**Planning Department
Transportation Development Services**

September 21, 2015

Re: Advanced Auto Parts
2801 4th St., NW
Traffic Circulation Layout
Engineer's/Architect's Stamp dated 8-1-15 (H14-D041)

Based upon the information provided in your submittal received 9-17-15, the above referenced plan cannot be approved for Building Permit until the following comments are addressed:

1 SITE PLAN
C1 SCALE: 1" = 20'-0"

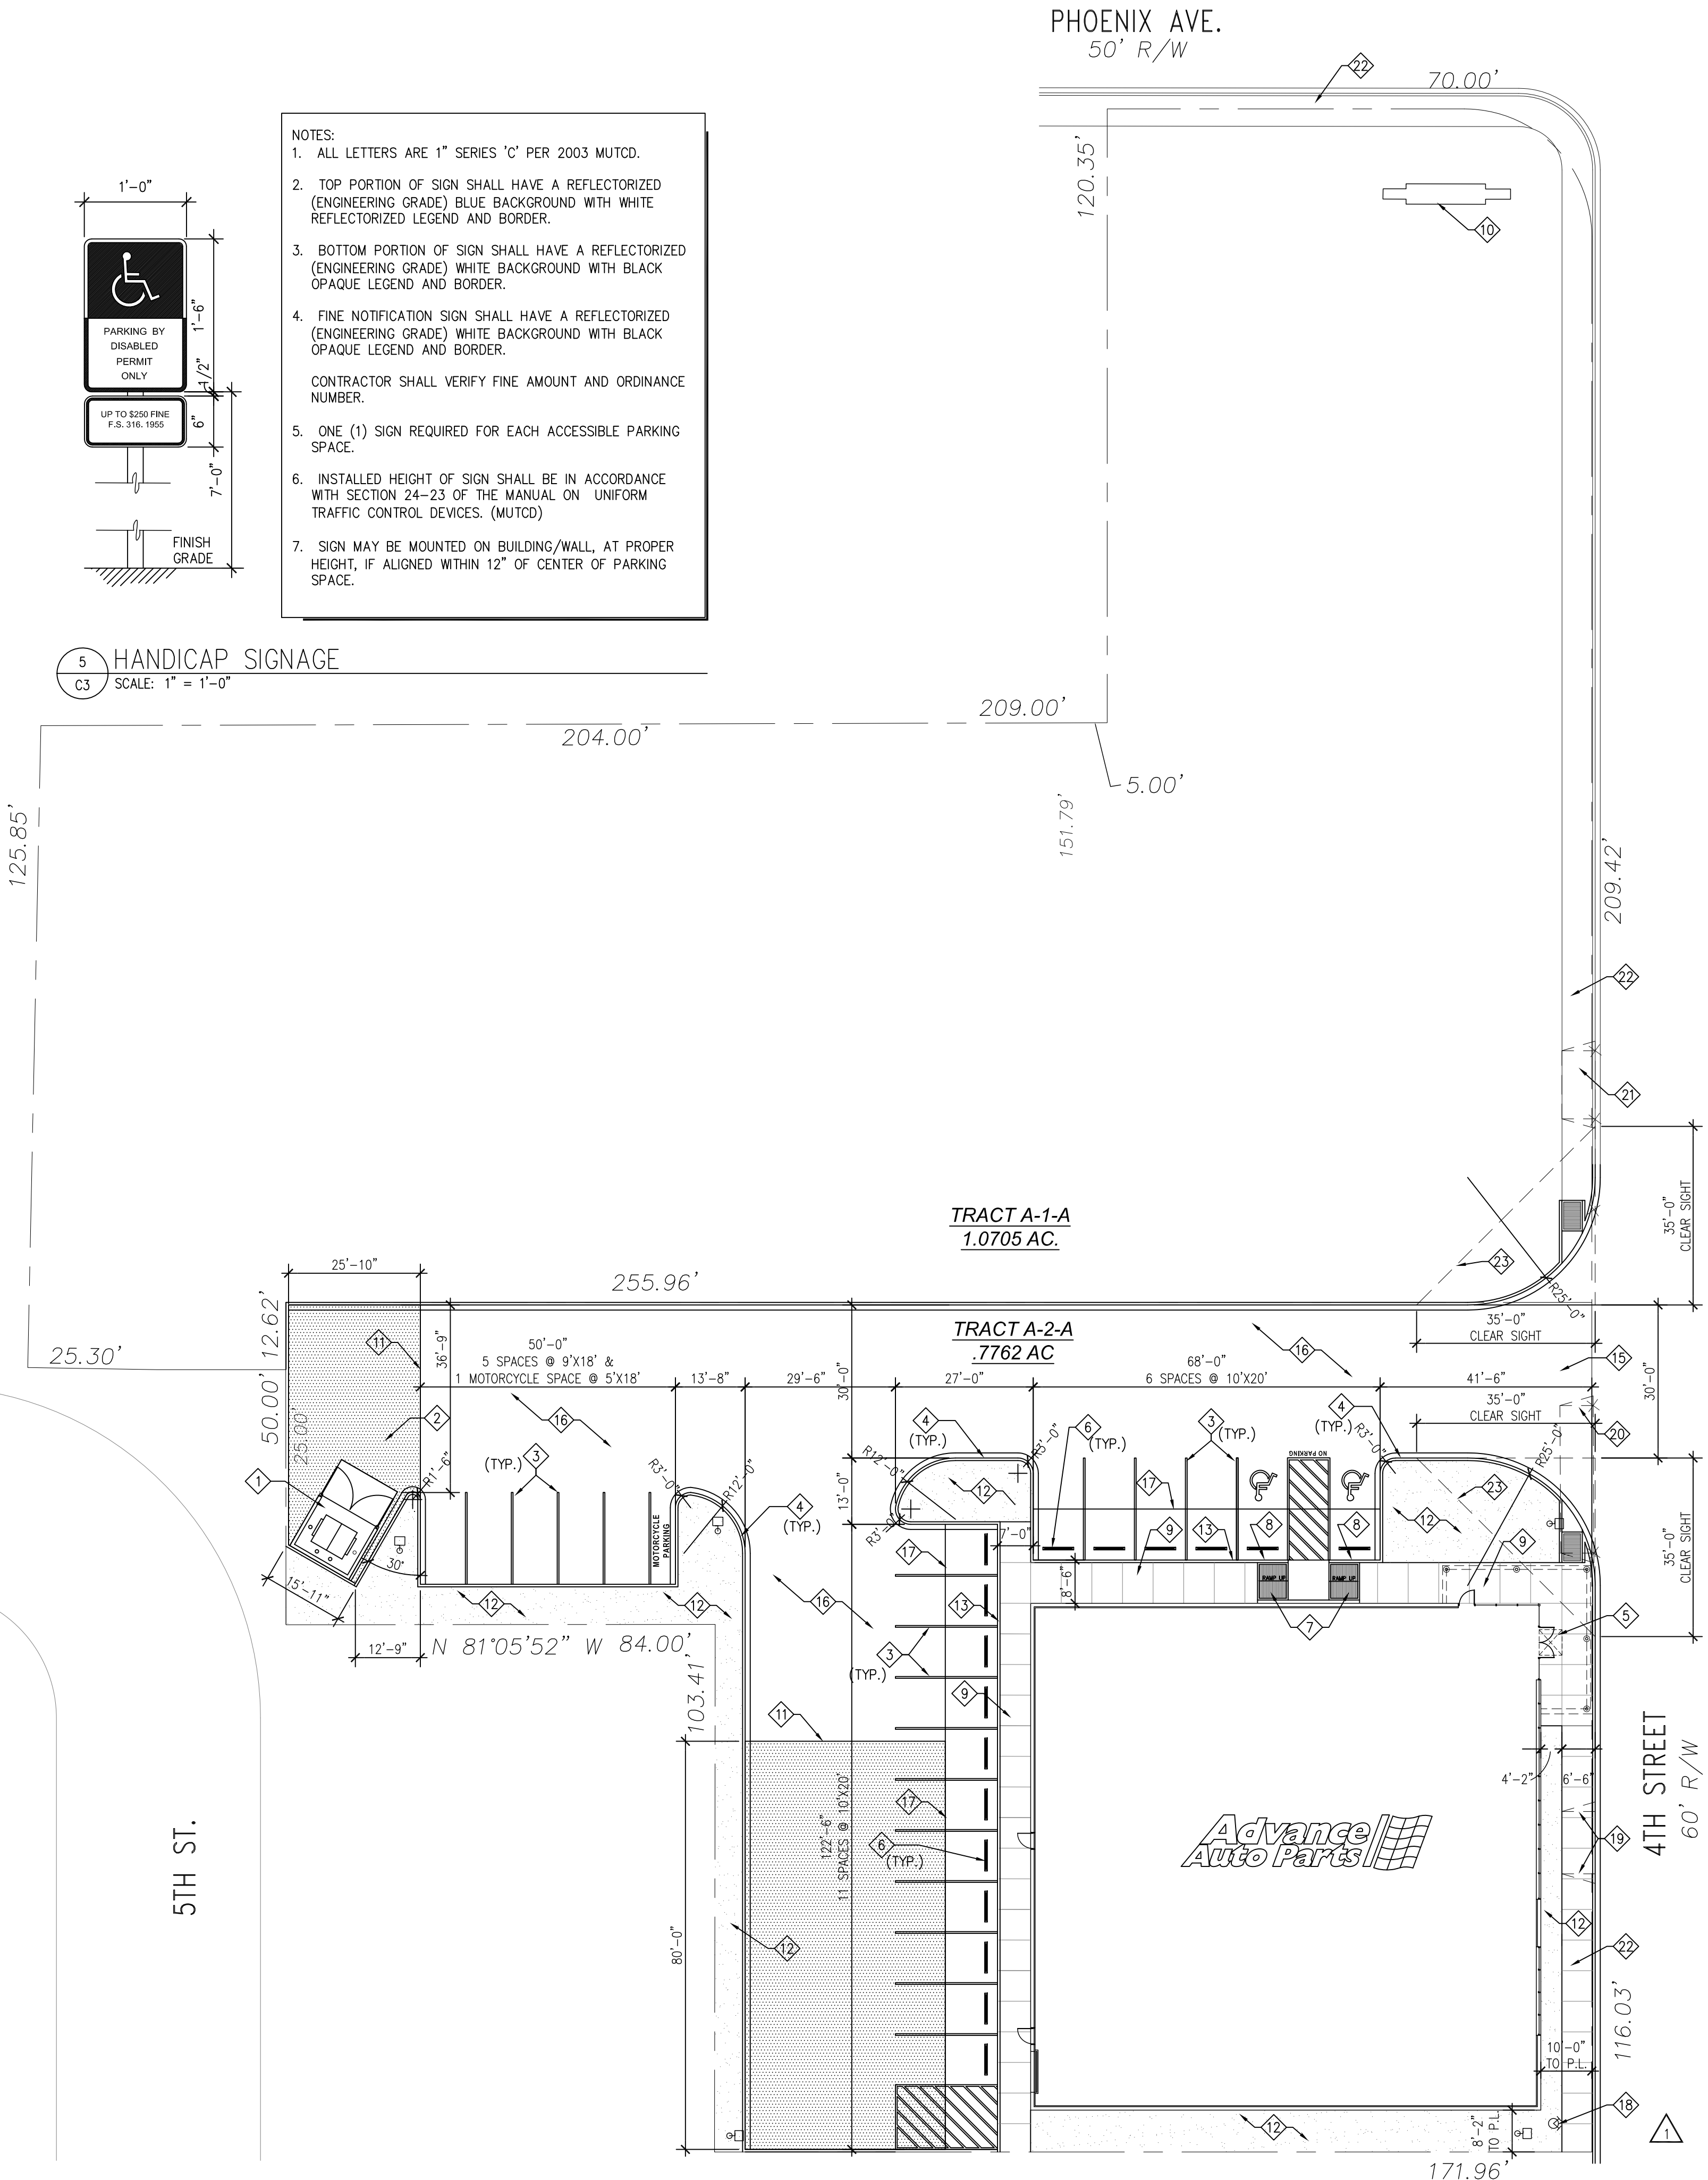
1. Clarify the extents of the current phase. Please detail or state if there is an existing building and if it is to be demolished.
2. Identify all existing access easements and rights of way with dimensions. Please clearly show right of way side walk and pedestrian pathways on 4th st.
3. Identify the right of way width, medians, curb cuts, and street widths on both 4th St. and Phoenix Ave.
4. Service vehicle and/or refuse vehicle maneuvering must be contained on-site; provide a copy of refuse approval.
5. Please provide a sight distance exhibit (see the *Development Process Manual, Chapter 23, Section 3, Part D.5 Intersection Sight Distance*). Please provide this detail for entrance on 4th St.

6. Please add the following note to the clear sight triangle: "Landscaping and signage will not interfere with clear sight requirements. Therefore, signs, walls, trees, and shrubbery between 3 and 8 feet tall (as measured from the gutter pan) will not be acceptable in this area."
7. Unused curb cuts must be replaced with sidewalk and curb & gutter. They must be shown and a build note must be provided referring to the appropriate City Standard drawing.
8. Please include two copies of the traffic circulation layout at the next submittal.
